Application by RWE Renewables UK Solar and Storage Limited for Tween Bridge Solar Farm Project

The Examining Authority's written questions and requests for information (ExQ2): Issued on 07 July 2026

Figure 8.1: Designated Heritage Assets

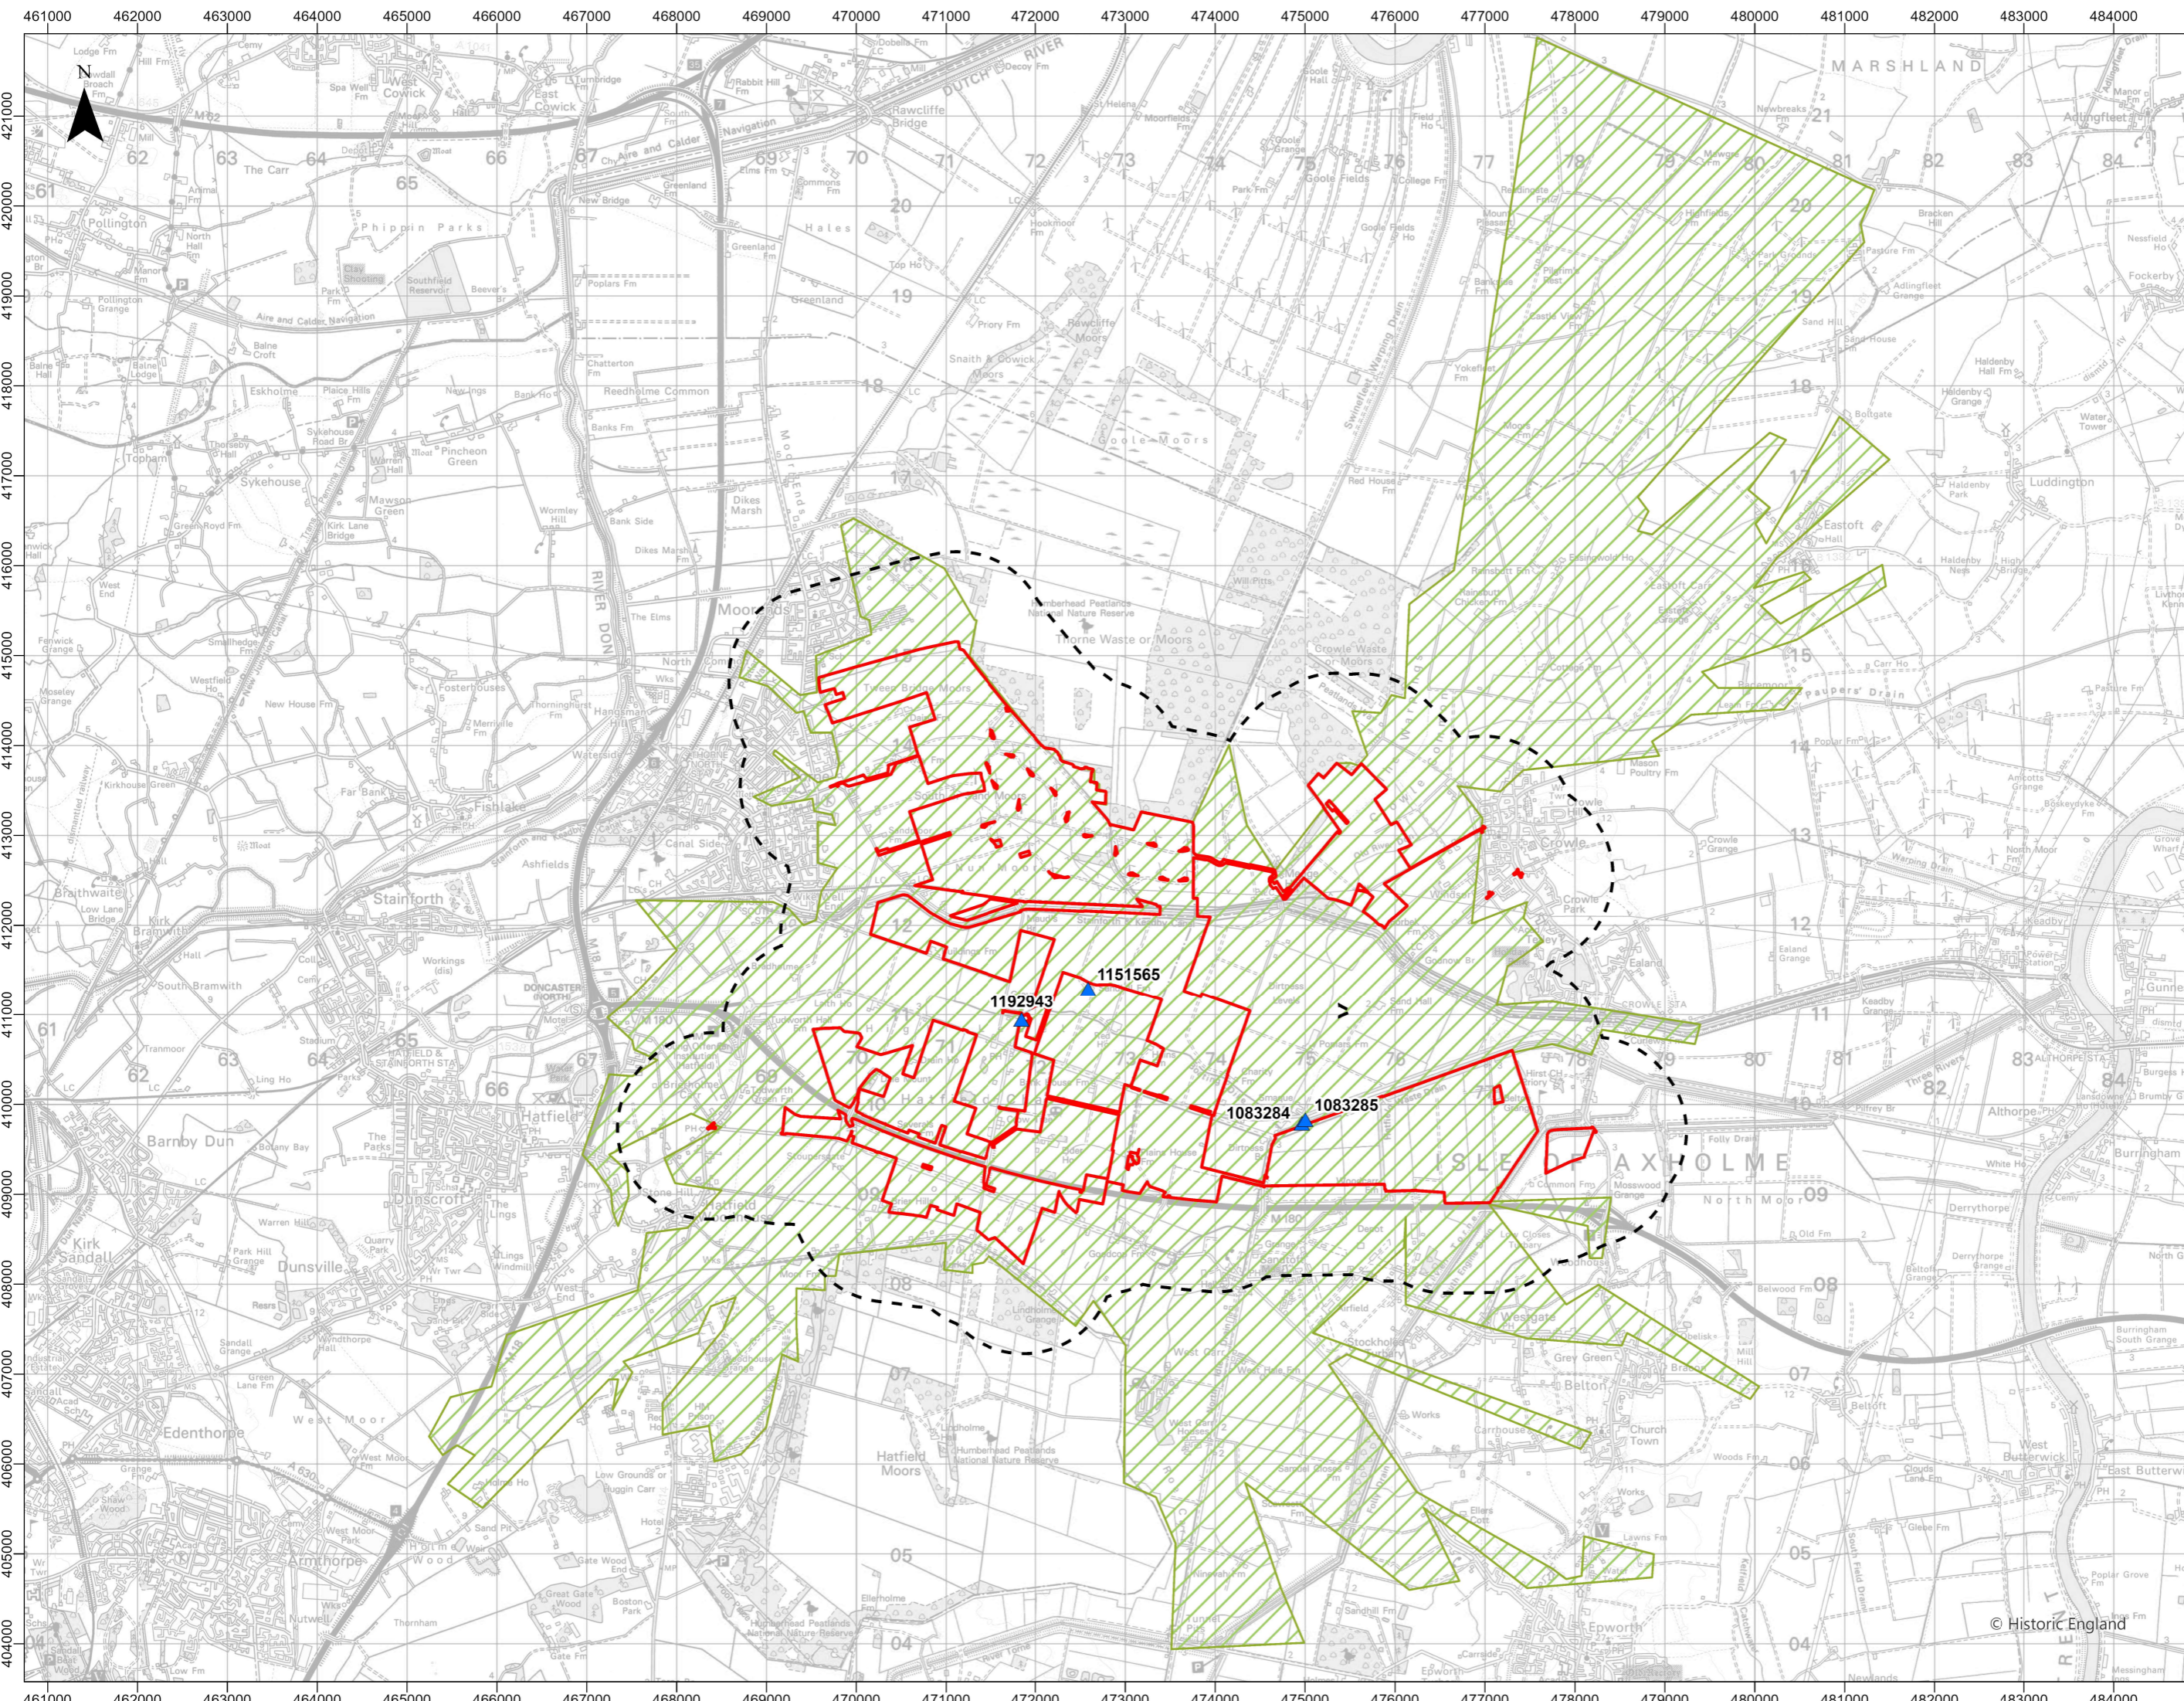
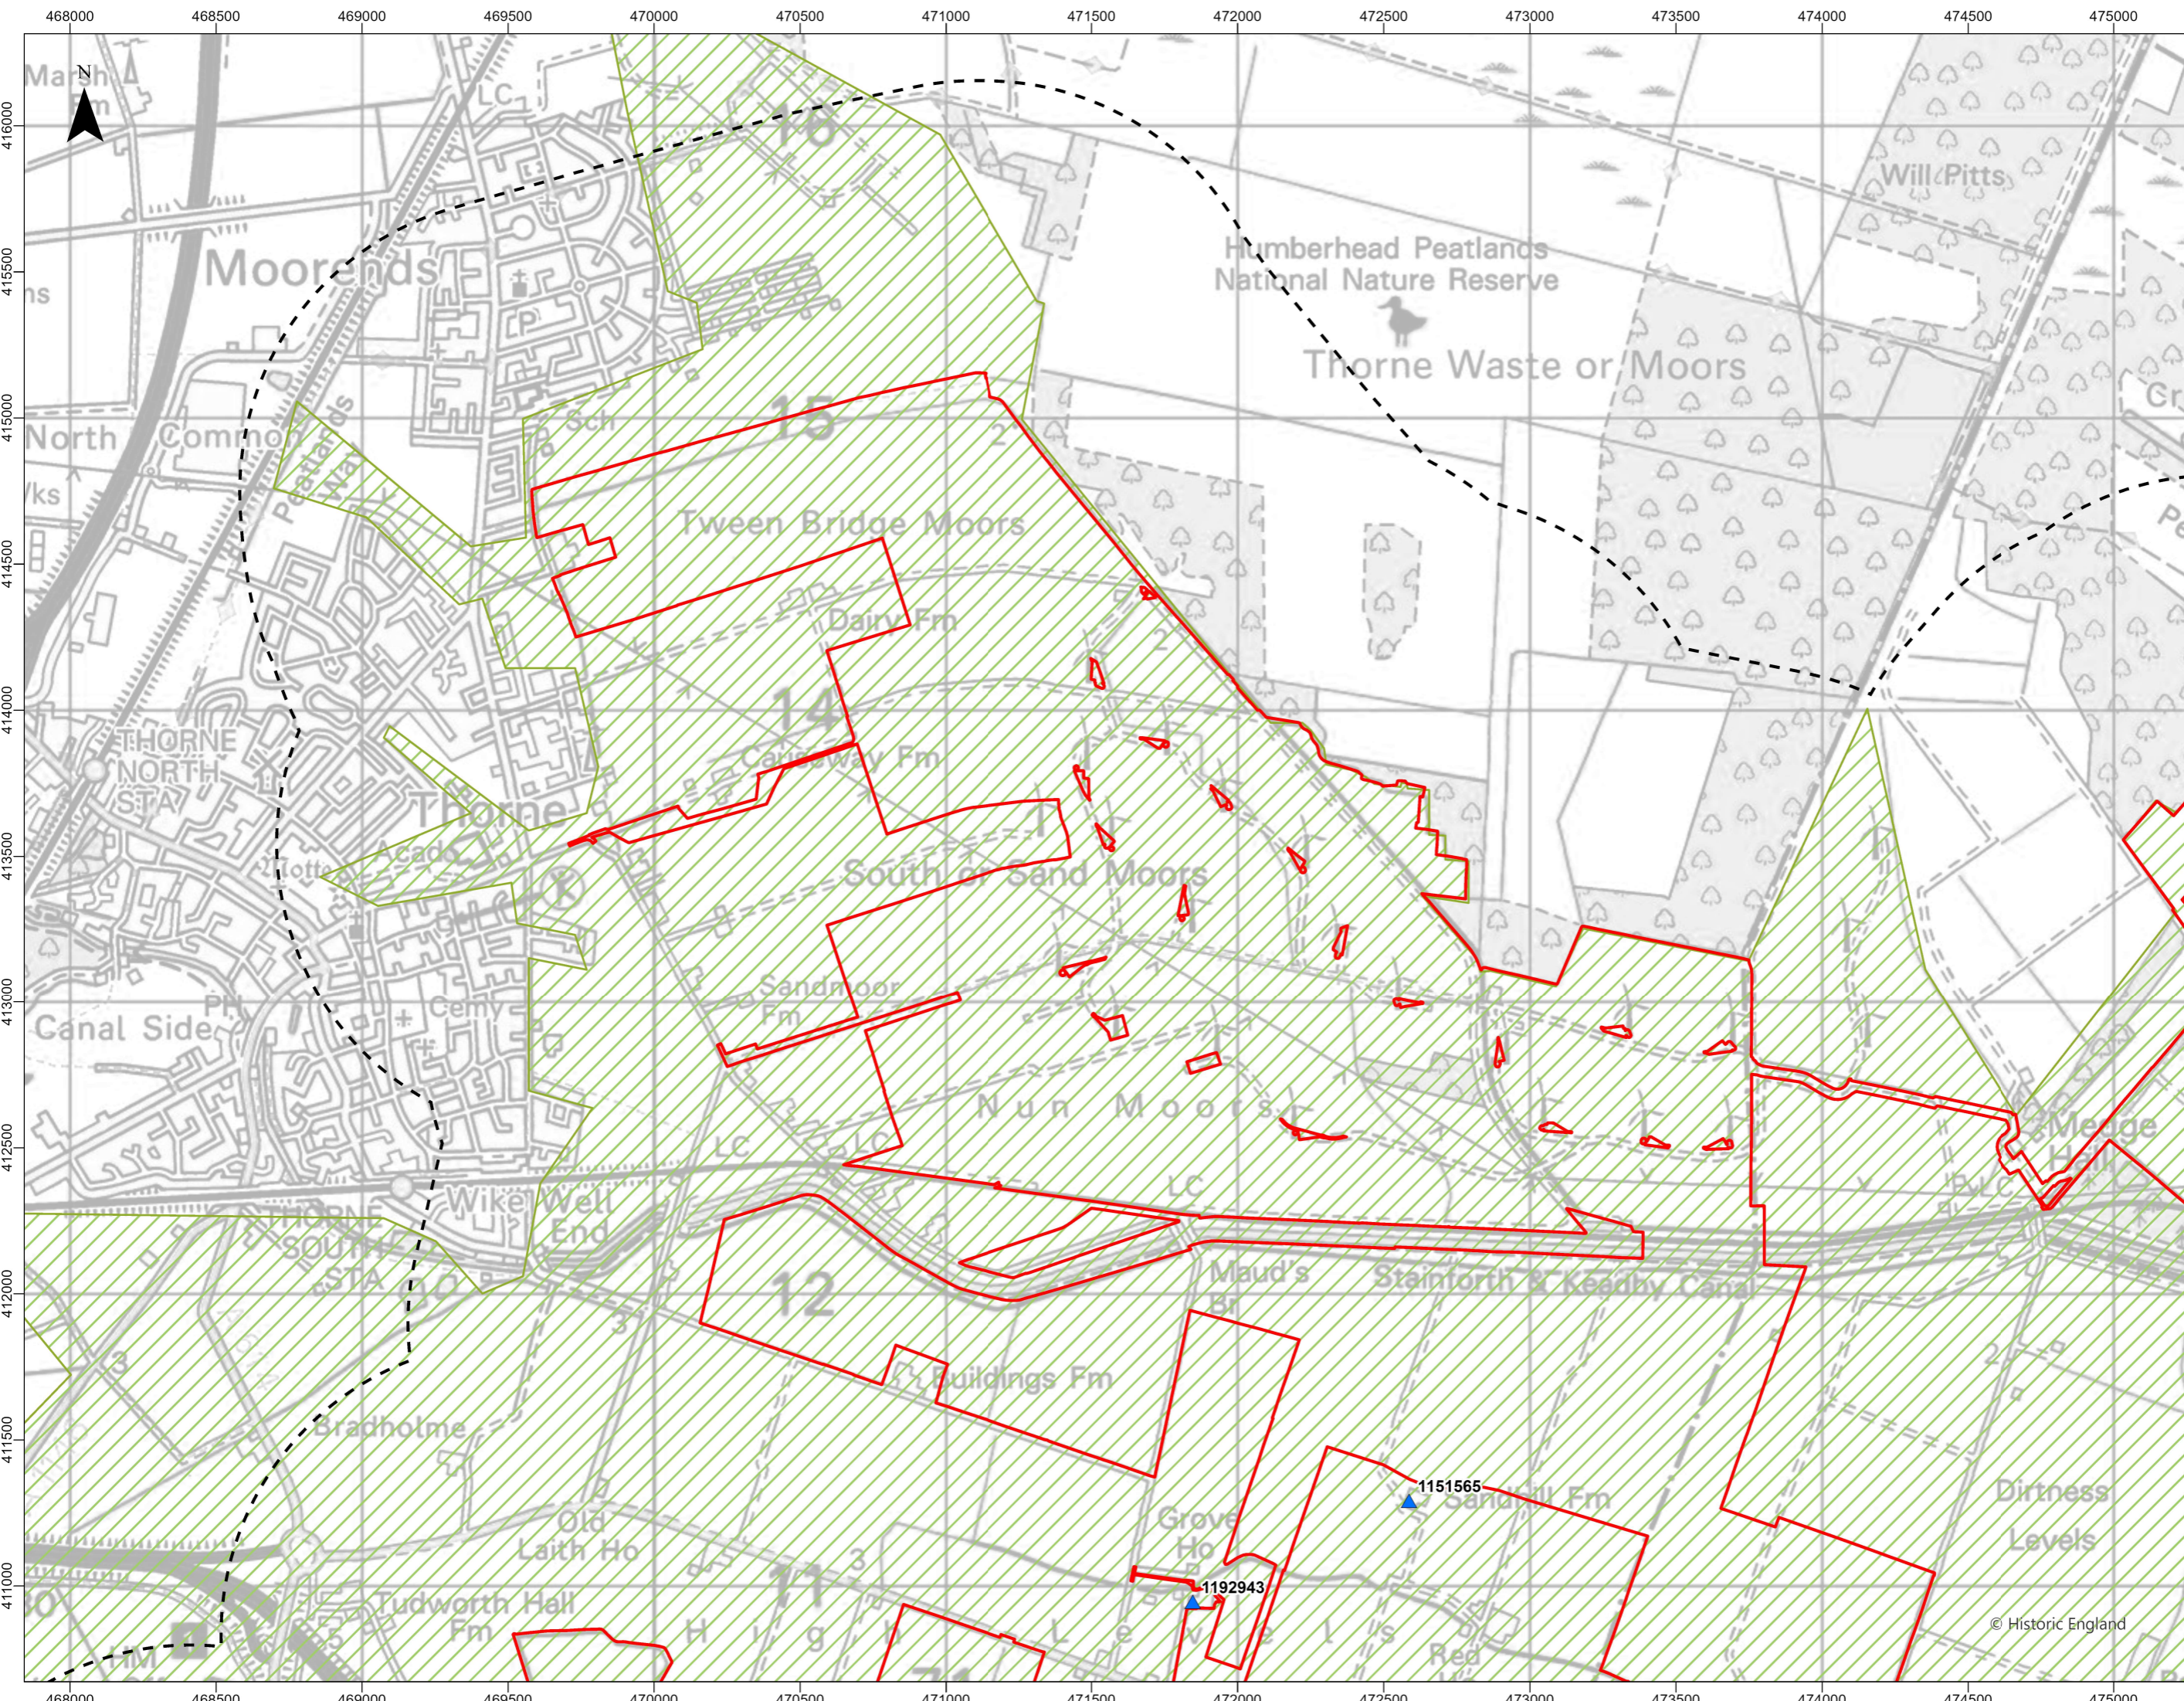
Q2.6.8	Applicant	Heritage assets The applicant's response to EXQ1 6.0.3 [REP2-087] states in part: "The Applicant has revised Figure 1 in ES Appendix 8.1 Heritage Baseline Assessment Document Reference 6.3.8 Revision 2] to show all of the designated heritage assets within the SZTV or 1km buffer around the Order Limits". However, there appear to be some heritage assets located north of Sandtoft and south of the M180 which are within 1km of the order limits. There also appear to be an even larger number which are located within the ZTV (in Sandtoft for example). These are not shown on the figure and should be. They should also be assessed accordingly.
Q2.6.9	Applicant	Q6.0.10 The applicant has provided a response to EXQ1 Q6.0.10 [REP2-087]. However, could the applicant update the ES to include this explanation?
Q2.6.10	Applicant	Archaeology CDC's response to written question 6.0.7 [REP2-099] states in part: "Magnetometry has been relied on as the main evaluation technique but the influence of the alluvial deposits on the effectiveness of the geophysical survey technique has not been resolved. The applicants contend that the survey was targeted at understanding near surface archaeological remains- "Magnetometry was not intended for consideration of deep deposits" (APP-045 ES Ch 8. Table 8-3: Summary of Consultation)- and the geoarchaeological desk-based assessment is the only site wide consideration of the potential for deeply buried remains. In addition, the effectiveness of the geophysical survey in identifying near surface archaeological remains is uncertain. Cropmark data indicated Romano-British activity in the Sandtoft area. Area 3 of the trial trench evaluation targeted this area identifying a Romano-British settlement dated to the 2nd/ 3rd century recording features consistent with the cropmark evidence. Despite only being covered by, on average, 30cm-50cm of topsoil and subsoil, none of the features associated with this settlement were recorded as anomalies by the
